CITY OF PORTLAND

BUILDING PERMIT

Located At 20 BALLPARK DR

has permission to build a new Two Story Single Family Residence with an Attached Garage.
provided that the person or persons, firm or corporation accepting this permit shall comply with all of the provisions of the Statues of Maine and of the Ordinances of the City of Portland regulating the construction, maintenance and use of the buildings and structures, and of the application on file in the department.

04/03/12 A0

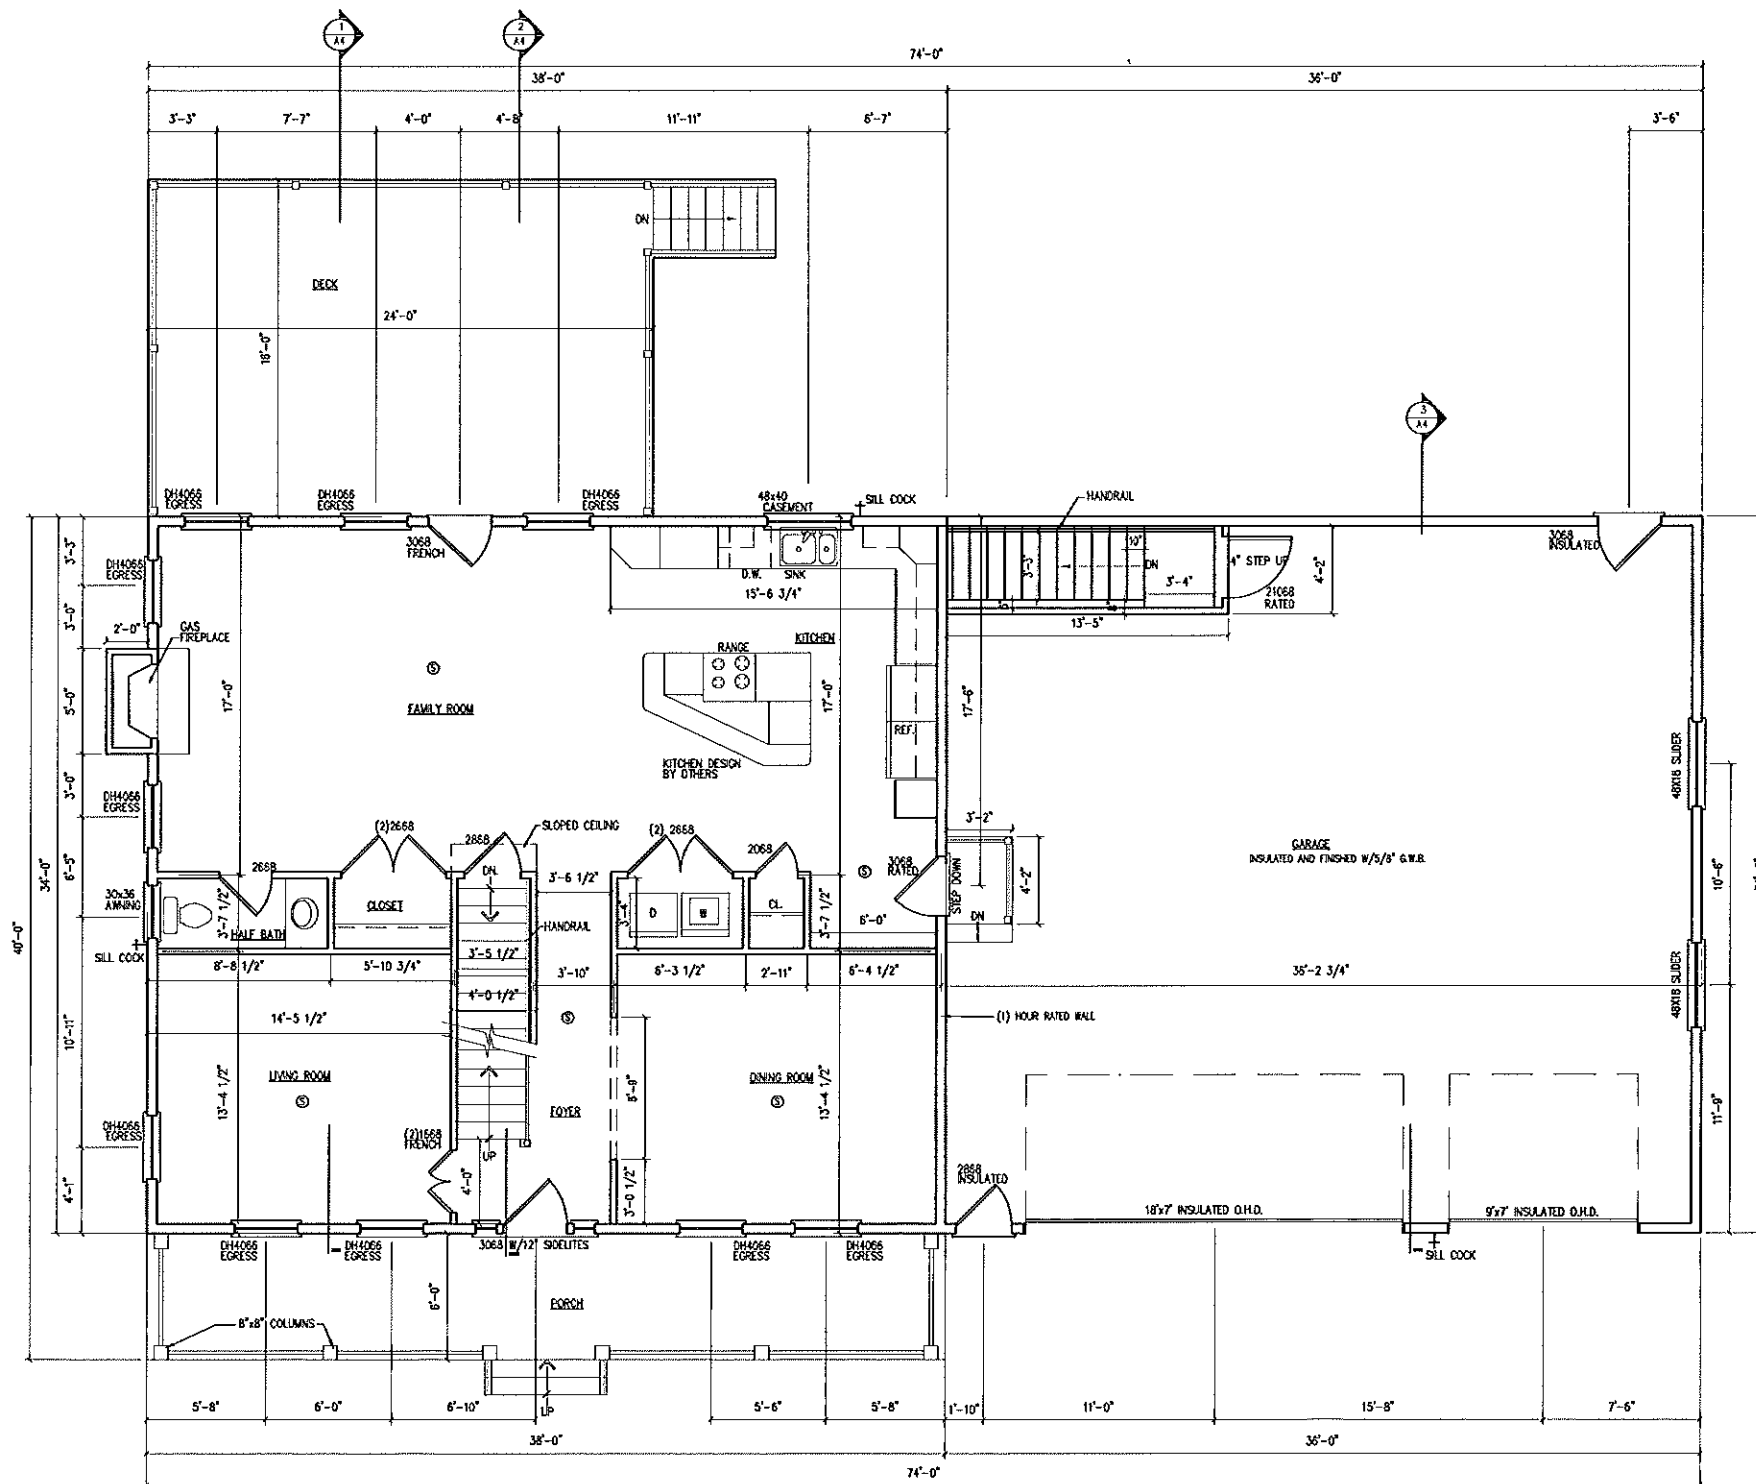
- The basement egress must open directly into a public way, or to a yard or court that opens to a public way (not the garage) This is not finished space therefore doesn't need to meet egress.

HOLDEN RESIDENCE PORTLAND, MAINE	
DRAWINGS THIS SHEET SECTIONS	
A4	04/03/12

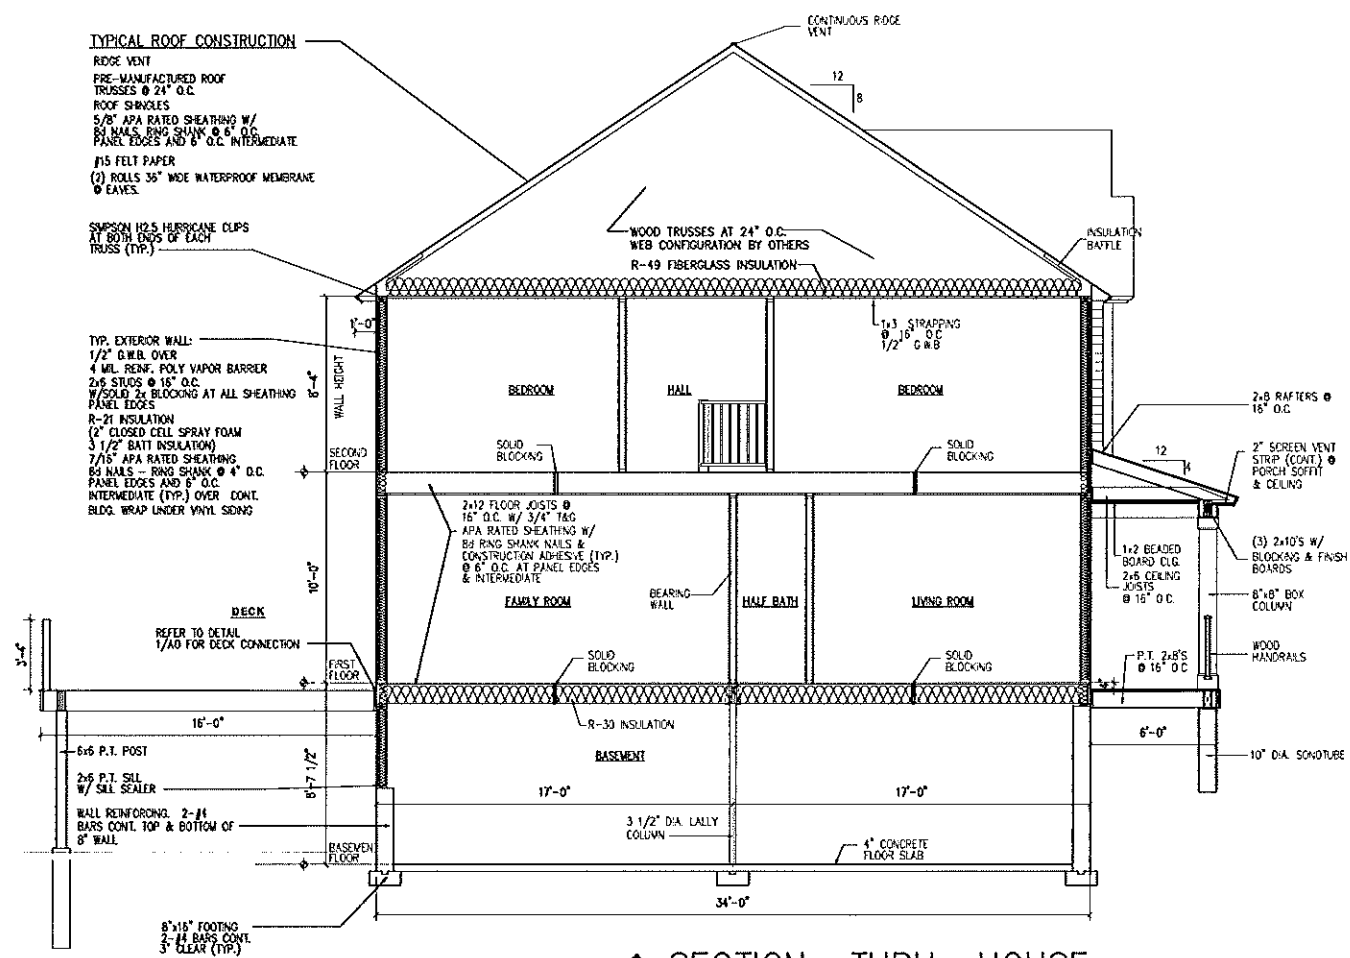
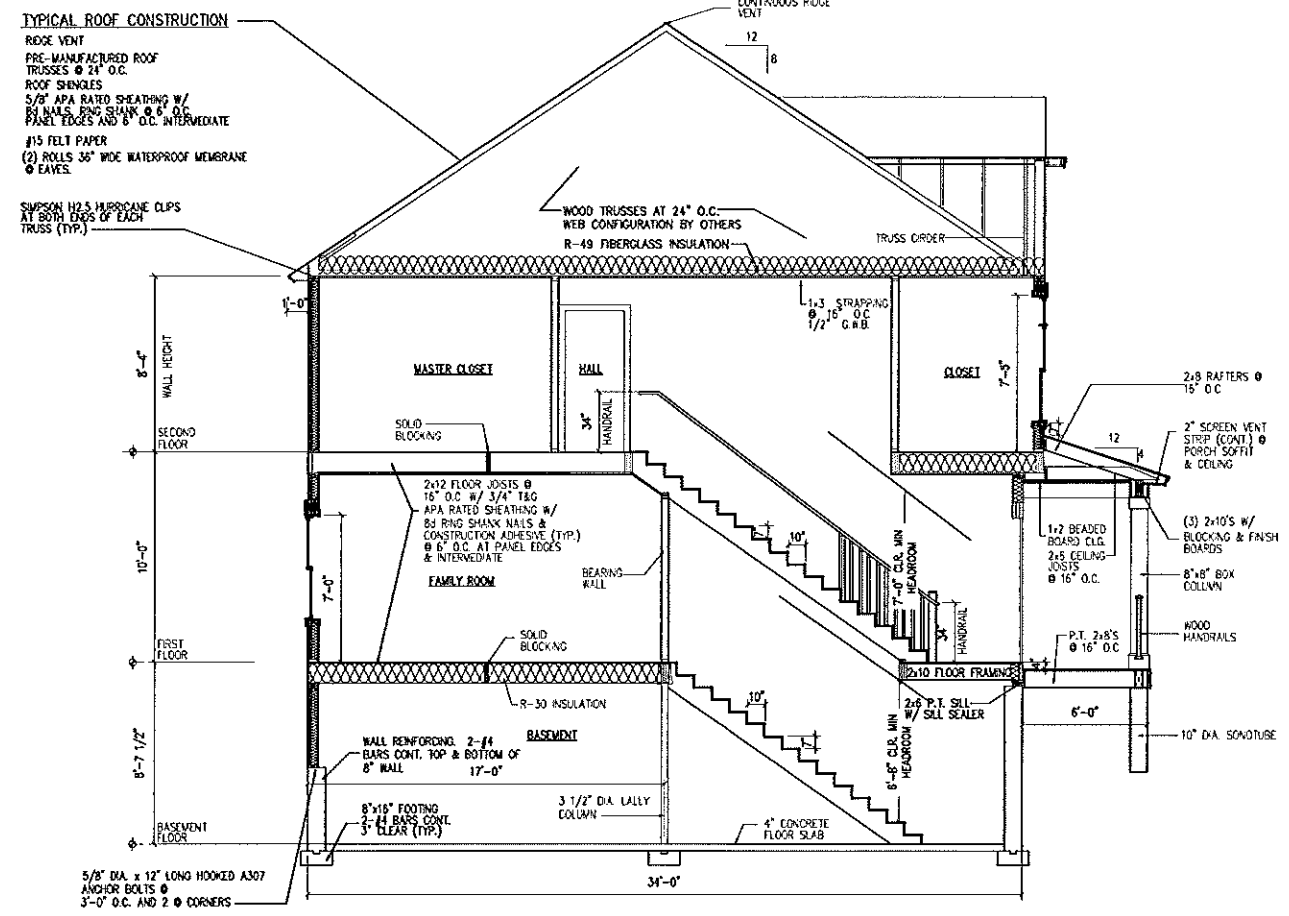
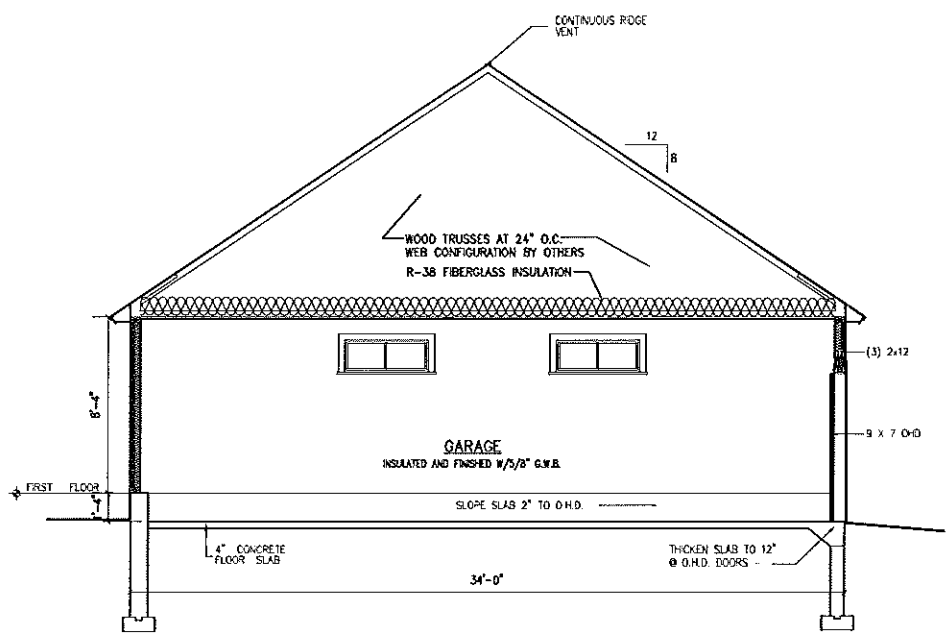
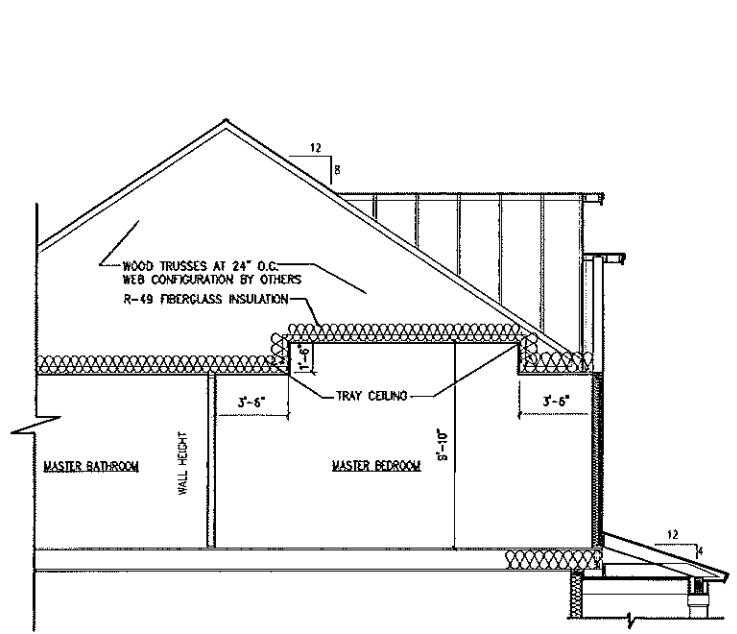
- R807.1 Attic access. Buildings with combustible ceiling or roof construction shall have an attic access opening to attic areas that exceed 30 square feet and have a vertical height of 30 inches or greater. The vertical height shall be measured from the top of the ceiling framing members to the underside of the roof framing members. The rough-framed opening shall not be less than 22 inches by 30 inches and shall be located in a hallway or other readily accessible location .I believe it is shown on the plan in the large walk in master closet.
- Ventilation of this space is required per ASRAE 62.2 , 2007 edition. It should meet, it has continuous ridge vent and eaves
- Insulation shall comply with the IECC, 2009 (Maine State Energy Codes). It meets all new energy code insulation

With the truss specification does the attic meet the criteria below? Space is unfinished and only accessible from the scuttle.
